**CARTER ENGINEERING & CONSULTING, PLLC****STRUCTURAL + CIVIL**

Location: 104 Lonnie Betts Drive, Holly Springs, North Carolina 27540
Project: Gentry Doggendorf Residential: detached garage addition

The owner has contracted to construct a 36'x30' detached garage with roof truss framing. I have provided consultation and performed a review of the construction plans [reference the 11 page construction drawings by Home Work Services for the above location]. No exception is taken to the contractor's construction plans provided incorporation of the following provisions.

FOUNDATION PLAN
 SCALE: 3/16 IN = 1 FT

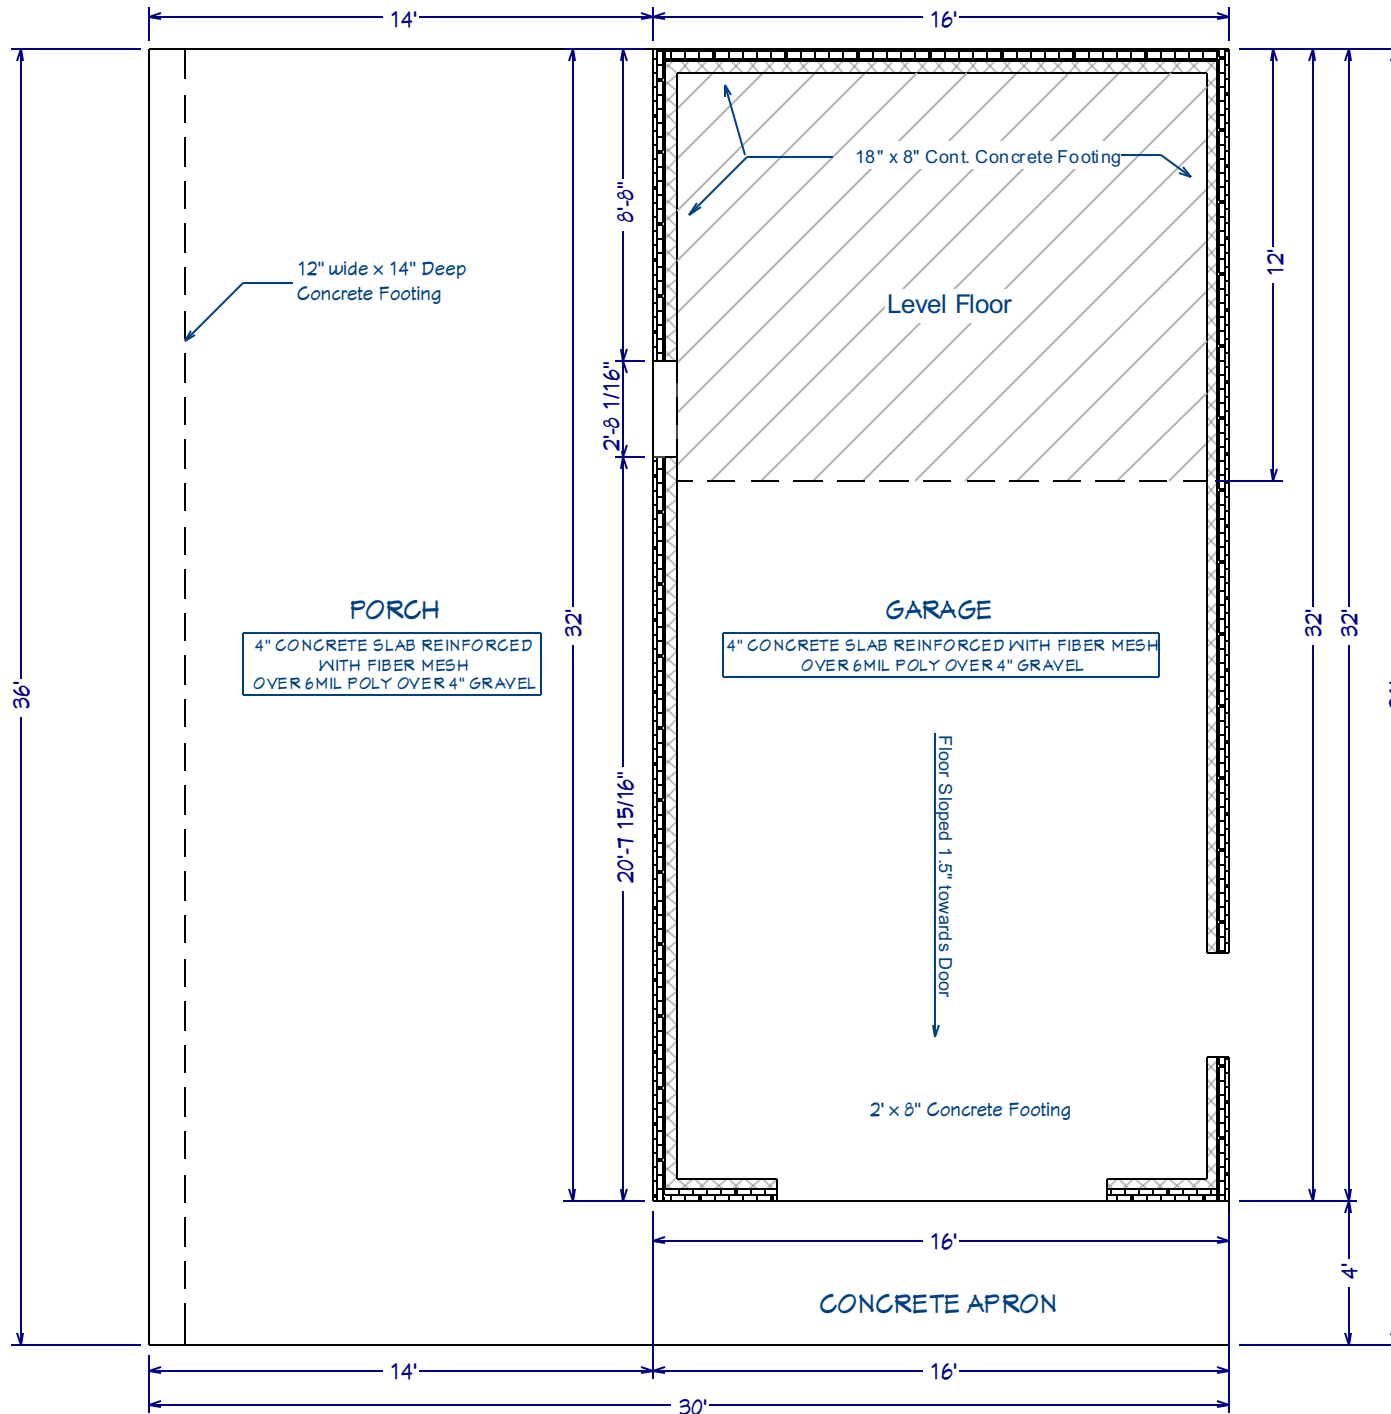
- All work shall be in compliance with the 2018 NCRC;
- Concrete slabs shall be constructed with standard control joints;
- LVL beam shall be fastened to the top of the column using an approved method;
- LVL beam bearing at garage wall framing shall be on 3 jack studs unless noted otherwise;
- Roof decking OSB shall be a minimum APA rated 24/16 Exp. 1;
- All mechanical connections shall use manufacturer specified fasteners filling all fastener slots;
- All engineered materials shall be installed per manufacturers specifications;
- Any conditions discovered to be non-compliant or present structural concern shall be immediately brought to the attention of the engineer of record.
